Subject: RE: Y/9818/RES and Y/97/18/DOC

Still not happy with the details or the proposed landscaping details. My original comments are shown in blue, the applicants responses are provided in red, and my responses to these are shown in *purple*:

Comments on the revised drainage and landscape proposals:

BOVIS HOMES
scheme: Land off Burndell Road Yapton
client: Bovis Homes
drawing: Hard Landscape Proposals
date: Nov. 2018
scale: 1:200@A1
drawing no: BOV22172 12E sheet 4
drawn: AE checked: DKM

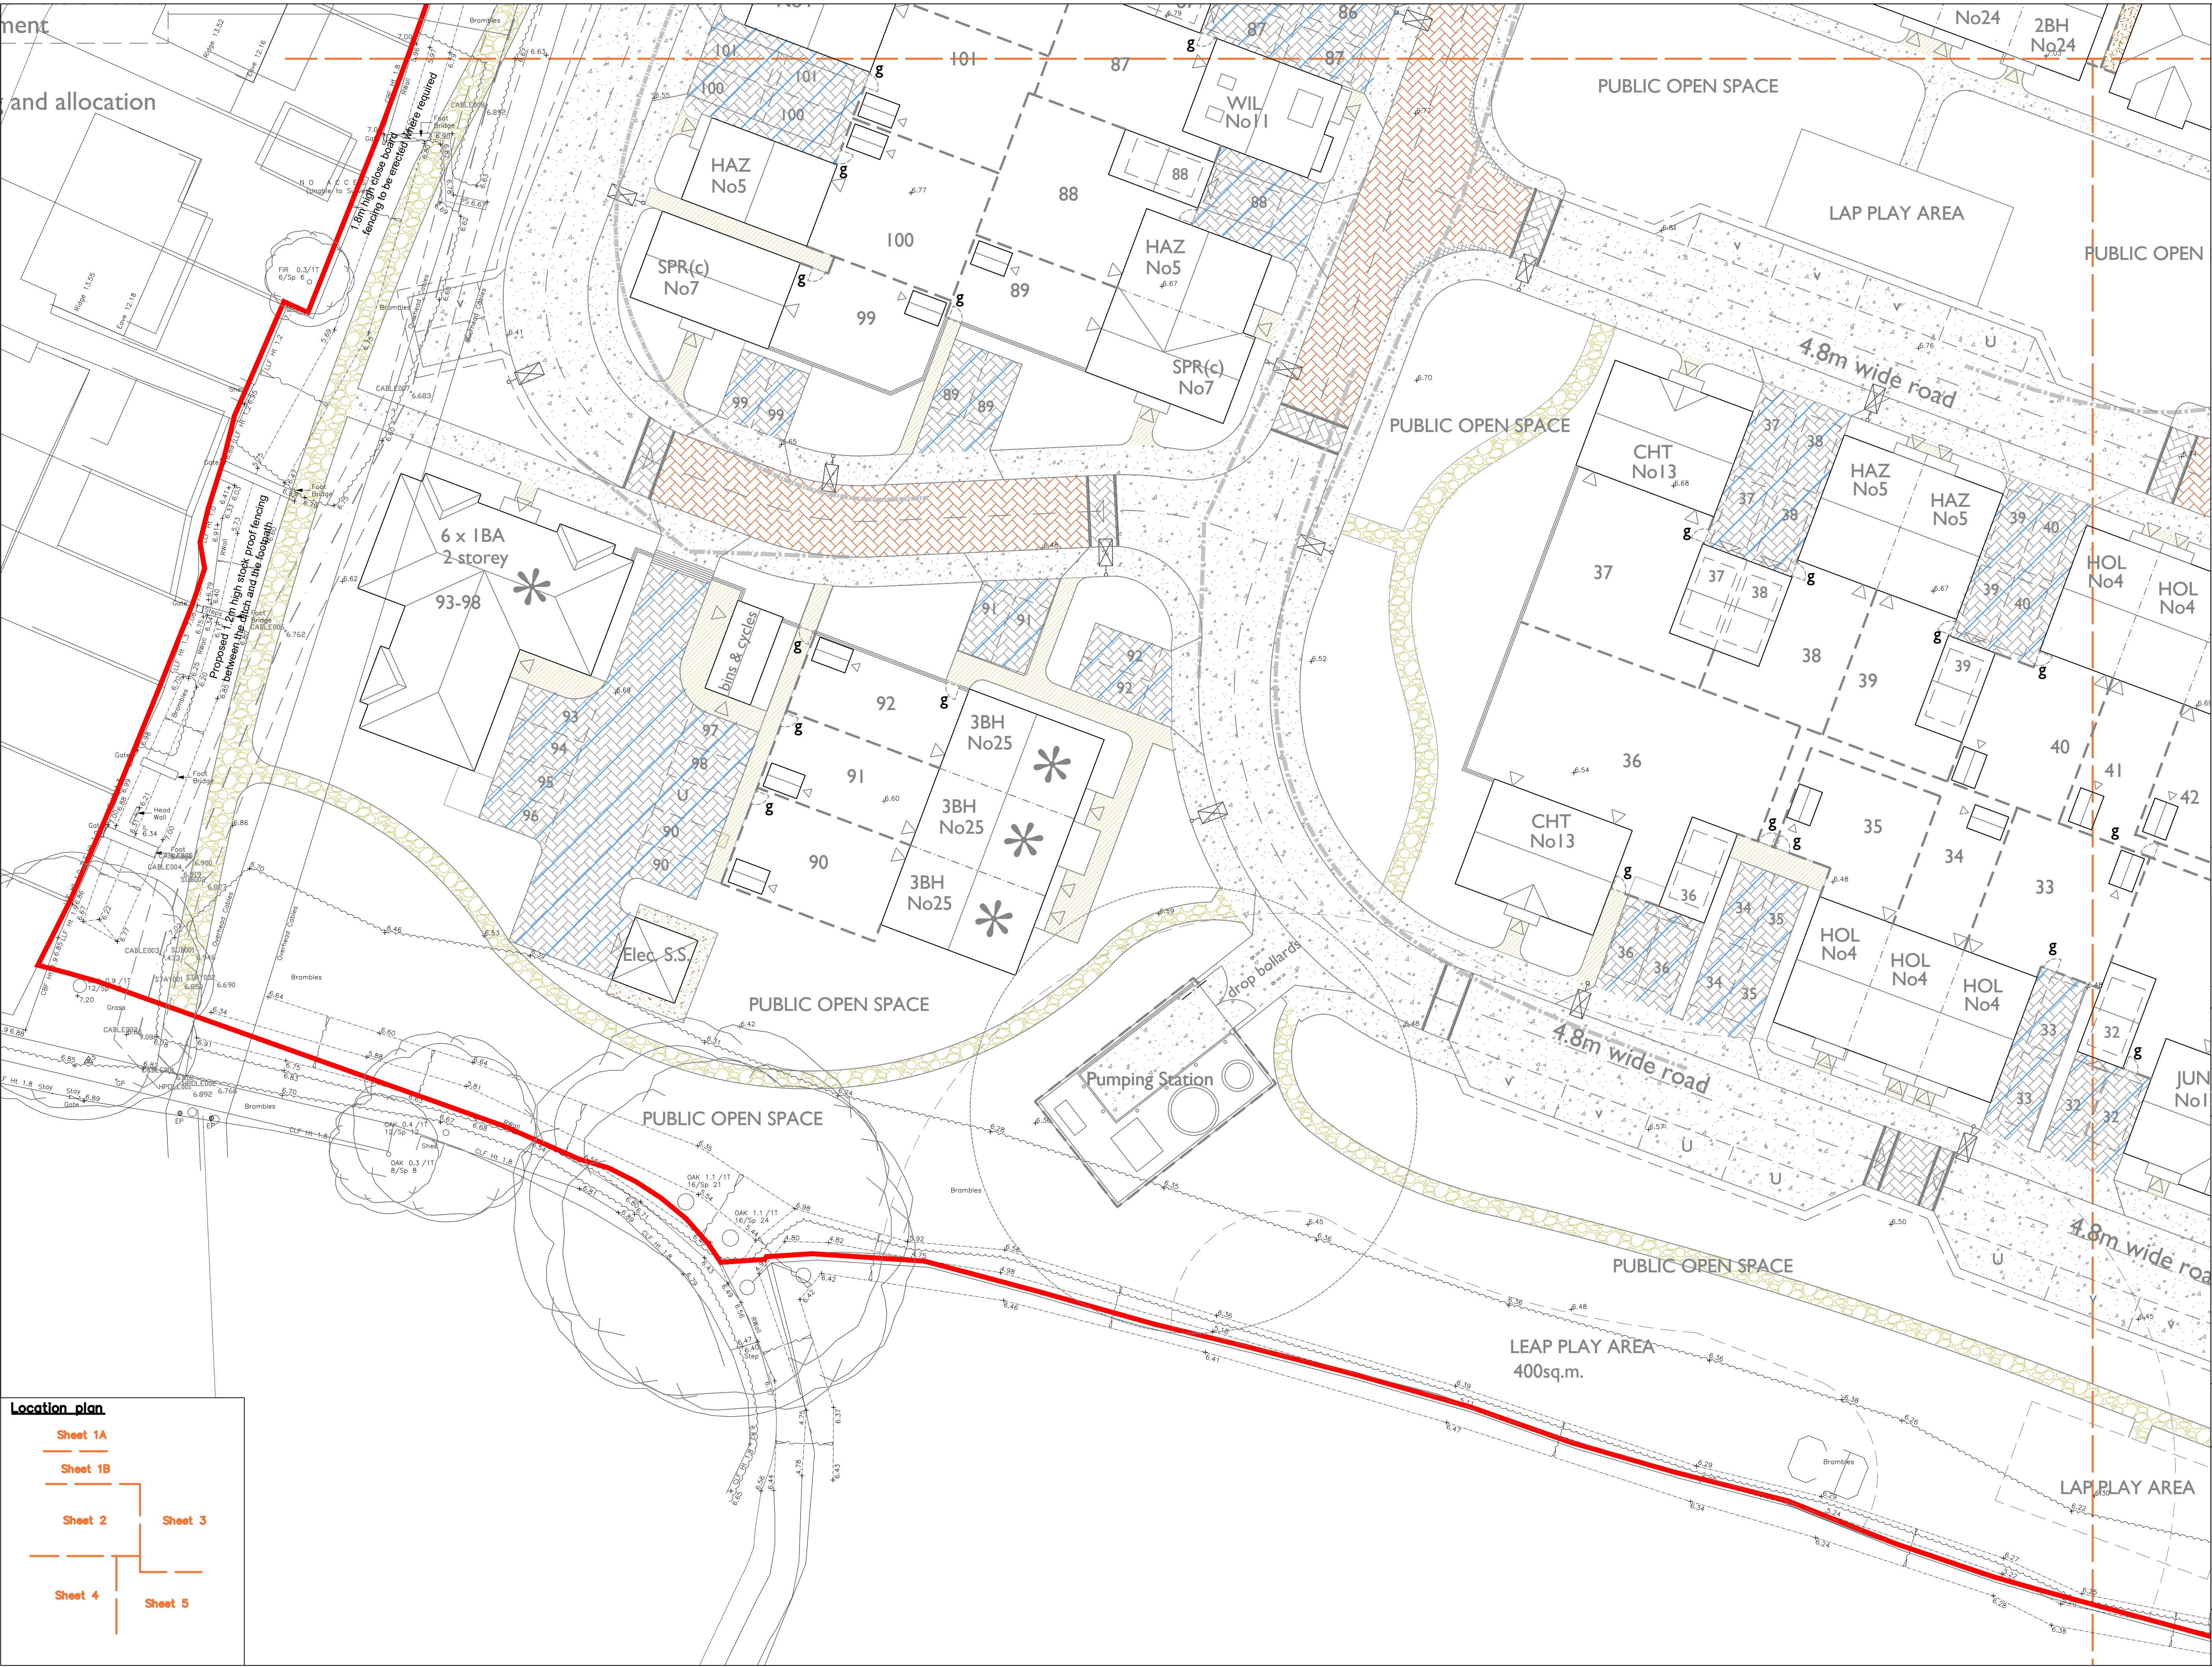
1. There are still trees proposed in close proximity to the southern-most attenuation tank. 2 no. trees close to this tank have been removed. Refer to updated ACD landscaping drawings. *On the ACD landscape drawing sheet 4 revision G there are trees in close proximity to the crate nearest the pumping station. Please can a plan be provided which shows both the proposed drainage and the proposed planting and associated potential root areas on the same drawing.*

1. There are still trees proposed in close proximity to the southern-most attenuation tank. 2 no. trees close to this tank have been removed. Refer to updated ACD landscaping drawings.

Job Title			
LAND SOUTH OF BURNDILL ROAD, YAPTON			
Drawing Title			
PRELIMINARY ENGINEERING LAYOUT			
Client			
BOVIS HOMES			
Scale	Date	Designed	SG
1:500 @A1	NOV 18		
Drawn	Checked	Approved	RS
SOM	LH		
Job No	Drawing No		Rev
18-070	18-070/103		P

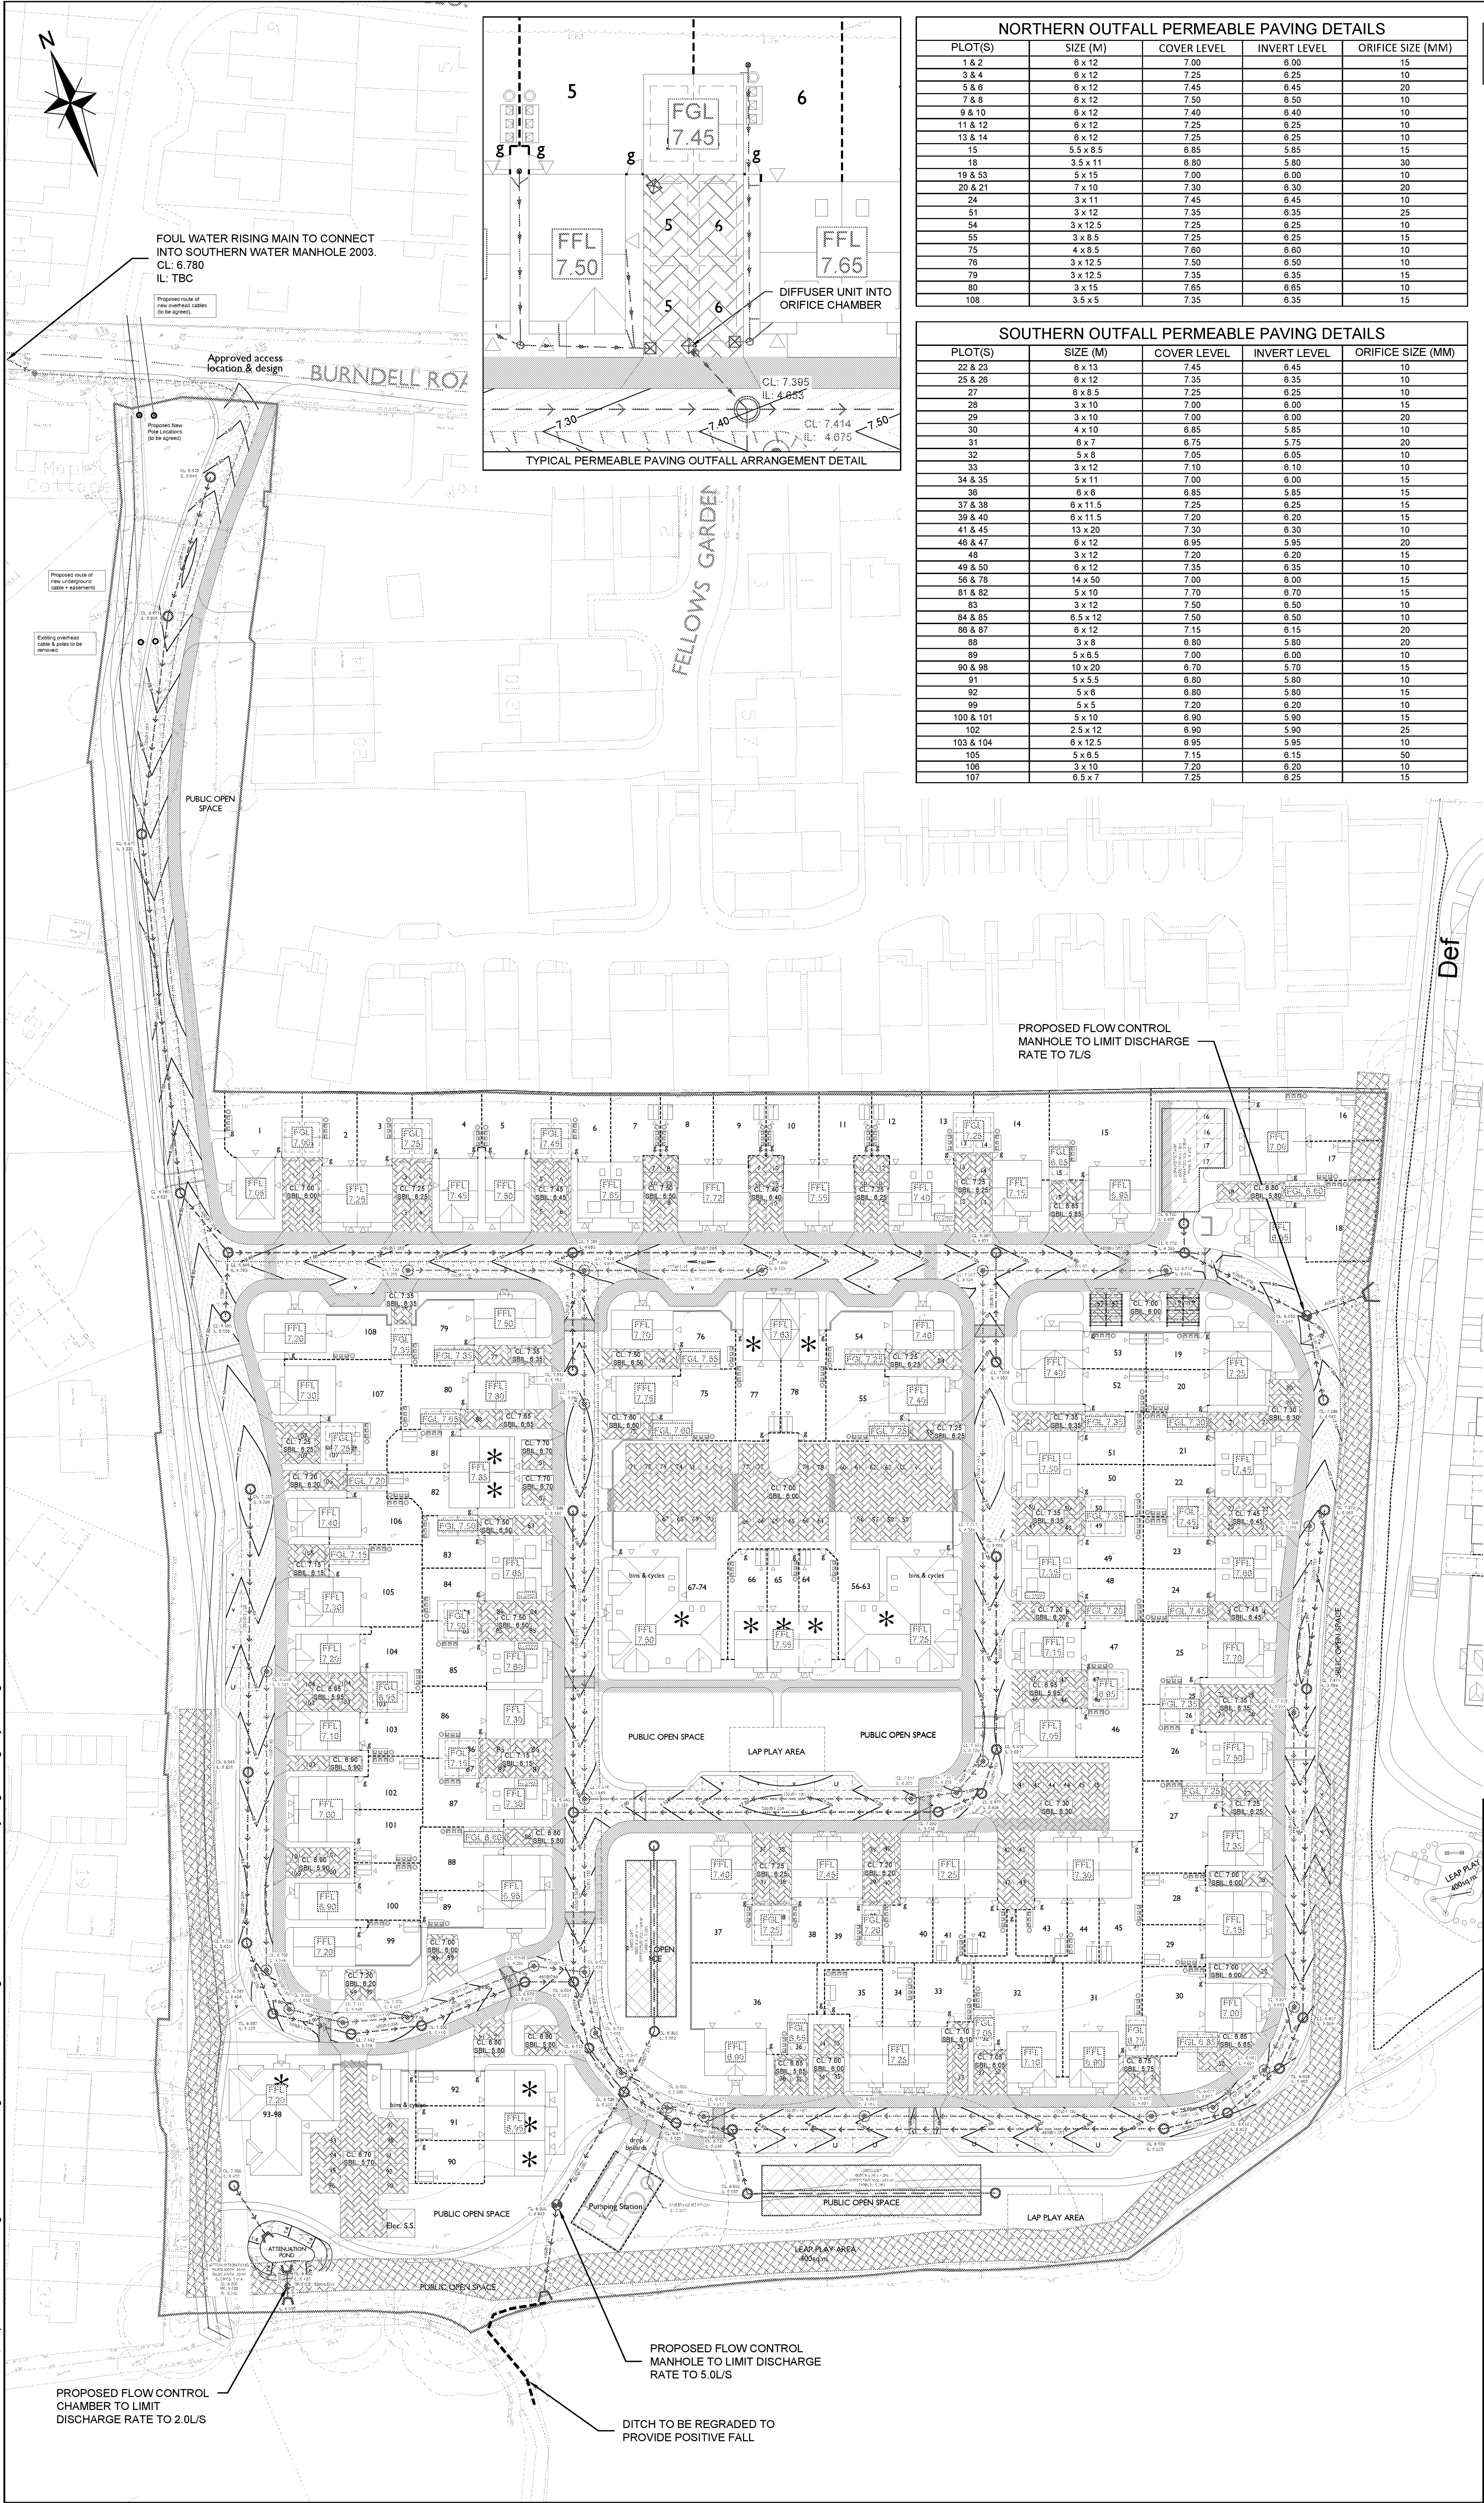
5. Calculations for attenuation basin attached. *Can you provide the full catchment calculations for this?*
6. We are proposing to diffuse rain water from roofs into the permeable paving and then connect the permeable paving to the wider sewer network (via a control). We show this typical arrangement, which applies to every drive, on the top right (inset) of drawing 18-070/103. *What size orifice are you proposing?*

6. Standard detail updated to show diffuser and control chamber together. Plan updated to show incoming surface water diffusers for typical drive. Permeable paving depths added to drawing (notes). Refer updated plans provided. *To clarify, are you proposing on diffusing rain water from roofs into permeable paving and then connecting the permeable paving to the wider network? You don't actually show control chambers near permeable paving on the layout. Please provide details on layout plans of the connectivity proposed.*

6. Details of how the permeable paving links to the main drainage system have not been provided. Typical arrangement/details have been shown on the drainage plan. These still don't seem to have been provided.

- a. *Construction detail drawings have been provided of diffuser units stating inlet from house, is this what is proposed? It isn't actually clear from the layouts if standard rwp connecting to the main piped network are proposed. There certainly are no diffuser units shown on layouts.*

- b. *There are still no drawings or indications on the layout of how the permeable paving connects to the main network. Please provide these. Please also ensure formation and finish levels of permeable paving is provided.*

- Updated engineering layout (permeable paving orifice range/reference added)
- Full network calculations
- Updated adoptable construction details (hydrobrake references updated)
- Updated private drainage details (standalone flow control IC added)
- Updated catchment plan
- Updated drainage technical note (amended drawings, calcs and additional flow control maintenance section added)

5. Drainage drawing shows smaller basin (as mentioned recently) and all associated basin levels. Refer to updated plan provided.
6. Standard detail updated to show diffuser and control chamber together. Plan updated to show incoming surface water diffusers for typical drive. Permeable paving depths added to drawing (notes). Refer updated plans provided.
